From: Kieran Carlin <kieran@carlinplanning.com>**Sent:** Wednesday 20 August 2025 16:56**To:** Breda Ingle <breda.ingle@pleanala.ie>; LAPS <laps@pleanala.ie>**Subject:** ABP-322359-25 - Dublin Street North and Backlands Regeneration Project

Ref. ABP-322359-25 - Dublin Street North and Backlands Regeneration Project

Proposal: Dublin Street North Regeneration Project

Drawing: RUSSEL ROW BOUNDARY PROPOSALS OVERVIEW PLAN 4

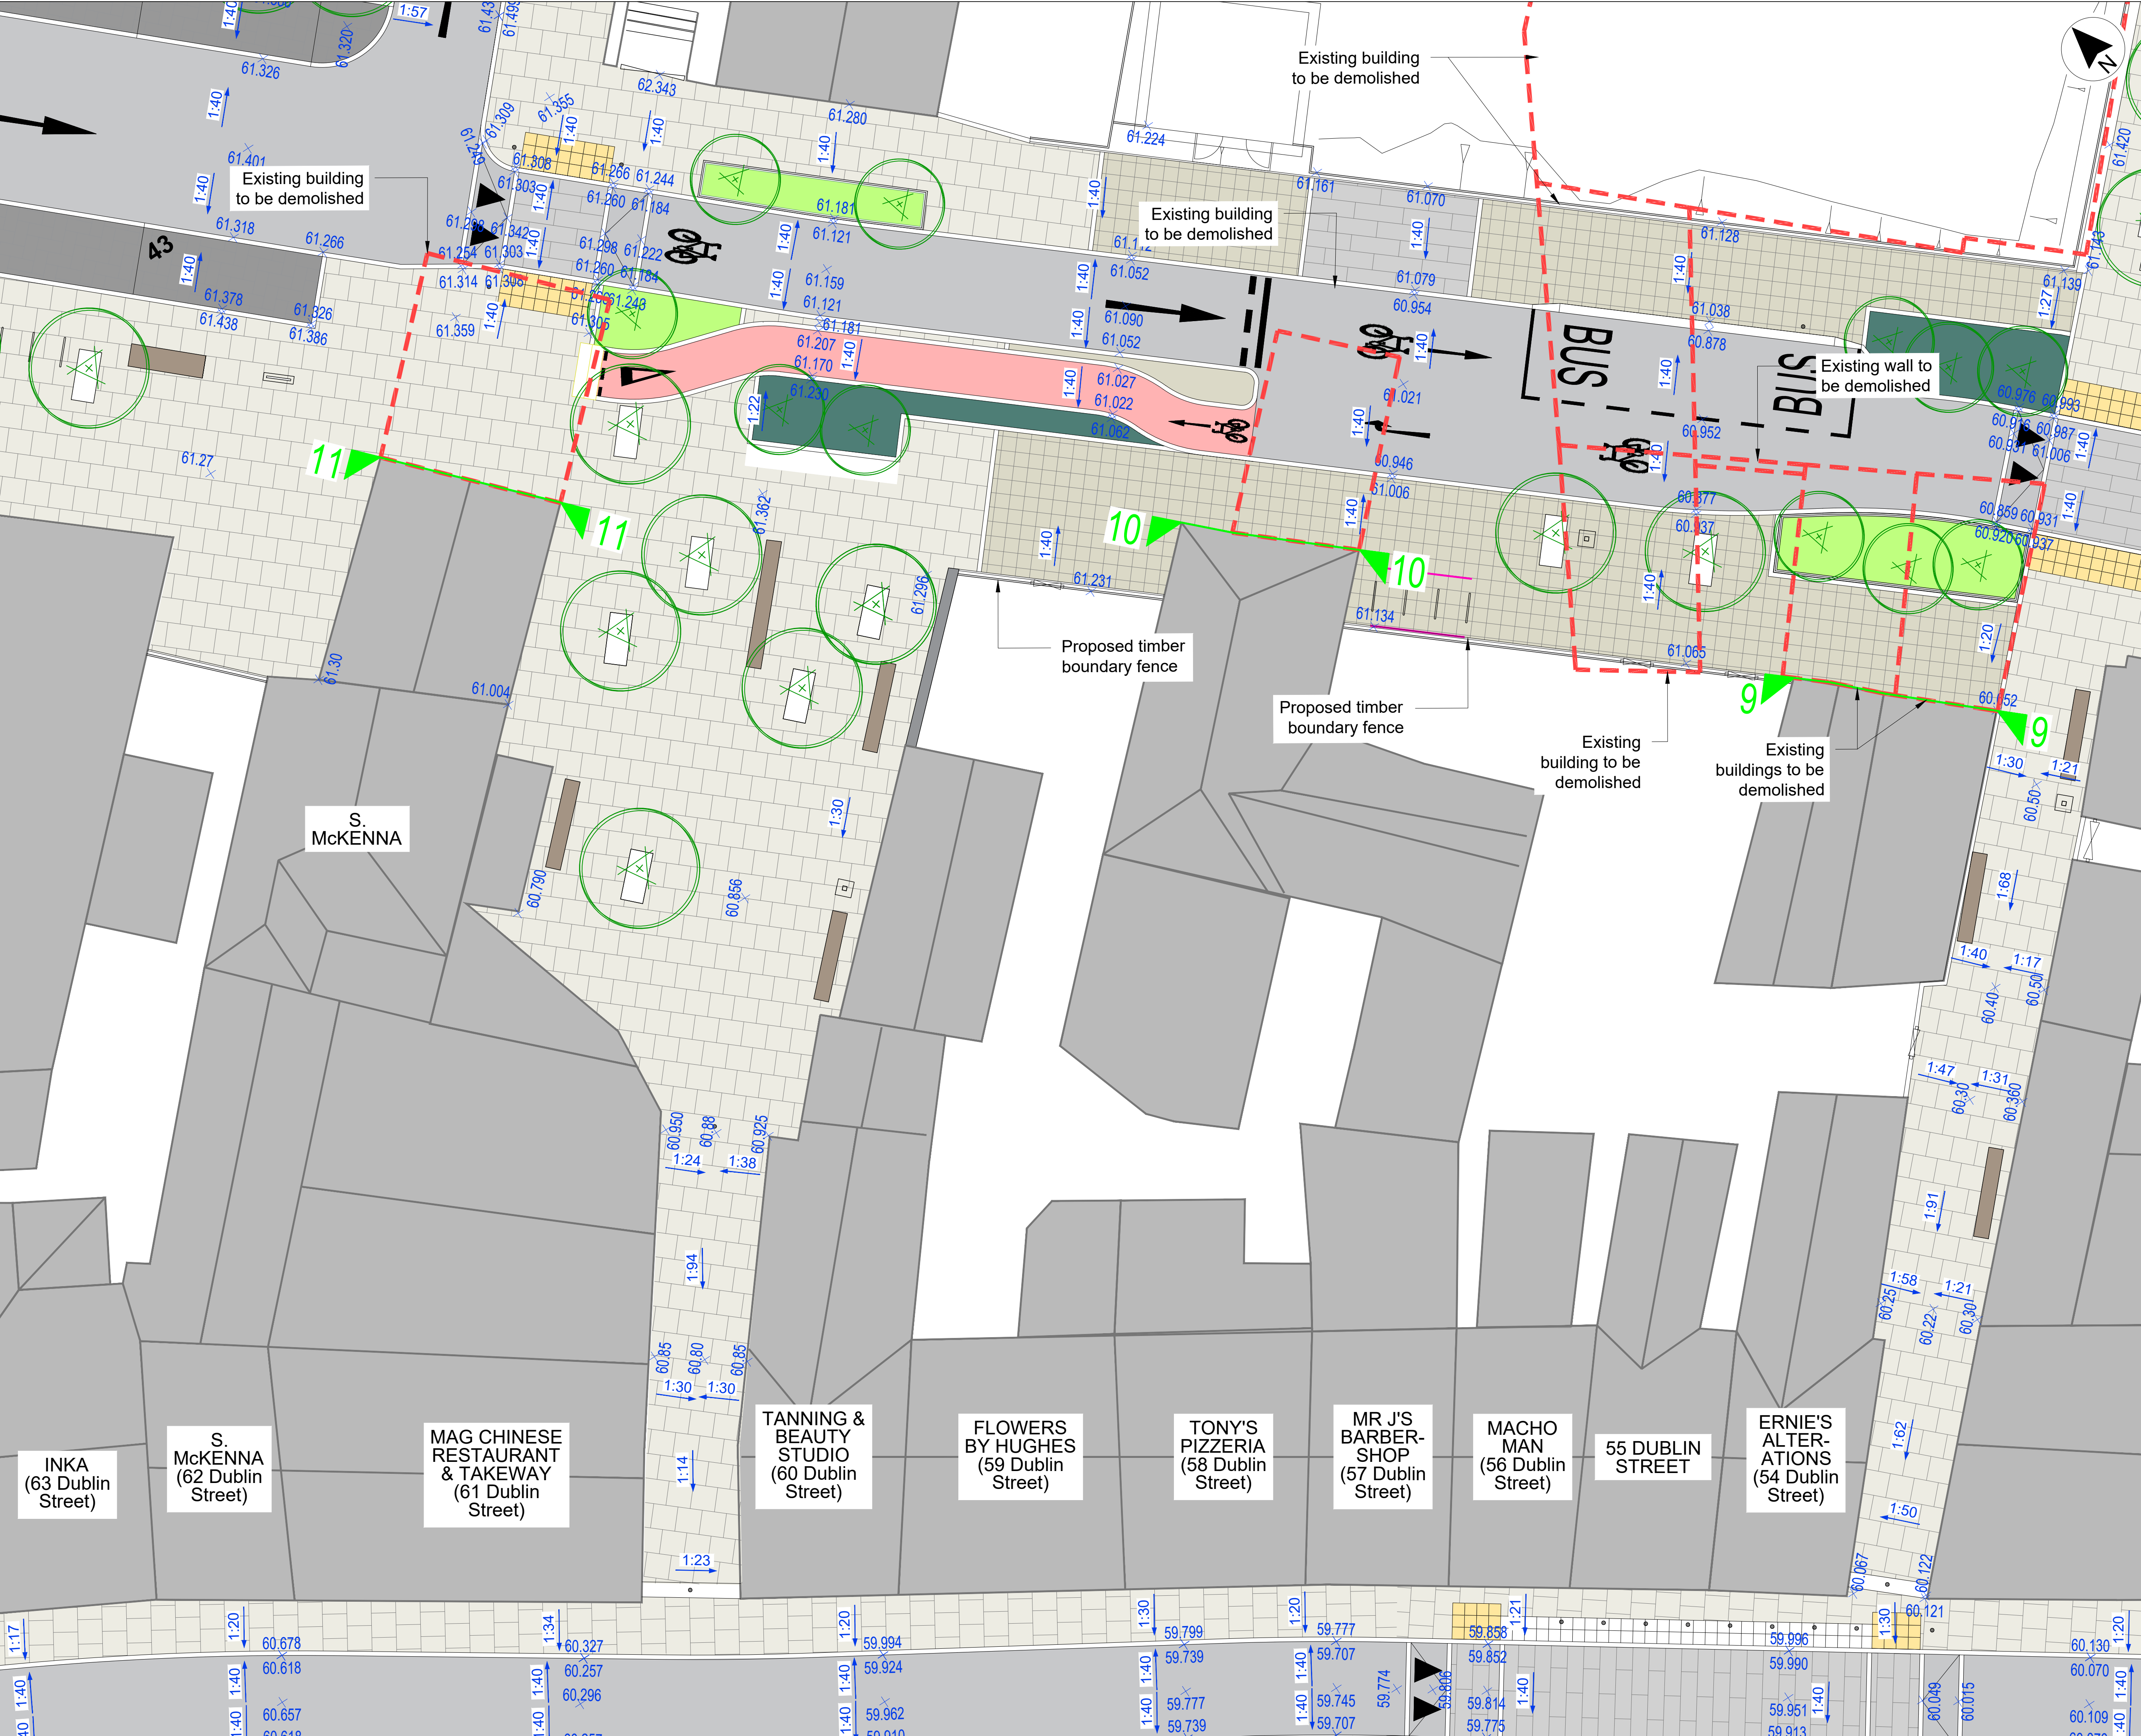
Submission	Summary of comments / issues	Action / Response
1. Cllr Sean Conlon	Objection to the proposed demolition of part of McKenna's public house.	MCC are committed to working with and supporting the local business community. Indeed, the central objective of the Dublin Street North Regeneration Masterplan is to enhance the vitality and viability of the town centre. It is considered that the retention of McKenna's property would not undermine the delivery of the Dublin Street North Regeneration Masterplan or conflict with the objectives of the Monaghan County Development Plan. While the illustrative Masterplan did show the property to be demolished and replaced with an 'infill' opportunity, we consider that it is appropriate not to demolish the property and to leave this decision to the landowner. This requires a minor alteration to the proposed site layout, which will involve the loss of a small area of

Submission	Summary of comments / issues	Action / Response
		proposed public realm. There is no impact upon the alignment of the proposed Russel Row. This minor alteration does not affect the conclusions of the Natural Impact Statement or Environmental Impact Assessment Report (EIAR). Please refer to Chapter 4 (Section 4.6.1) of the EIAR which sets out the construction methodologies for partial demolitions and proposed new building facades, masonry walls and gable returns. Accompanying this letter is a suite of amended plans, including the Proposed Site Layout showing the property now retained. The amendment, while minor, has resulted in a number of plans being updated to ensure consistency across the planning pack.
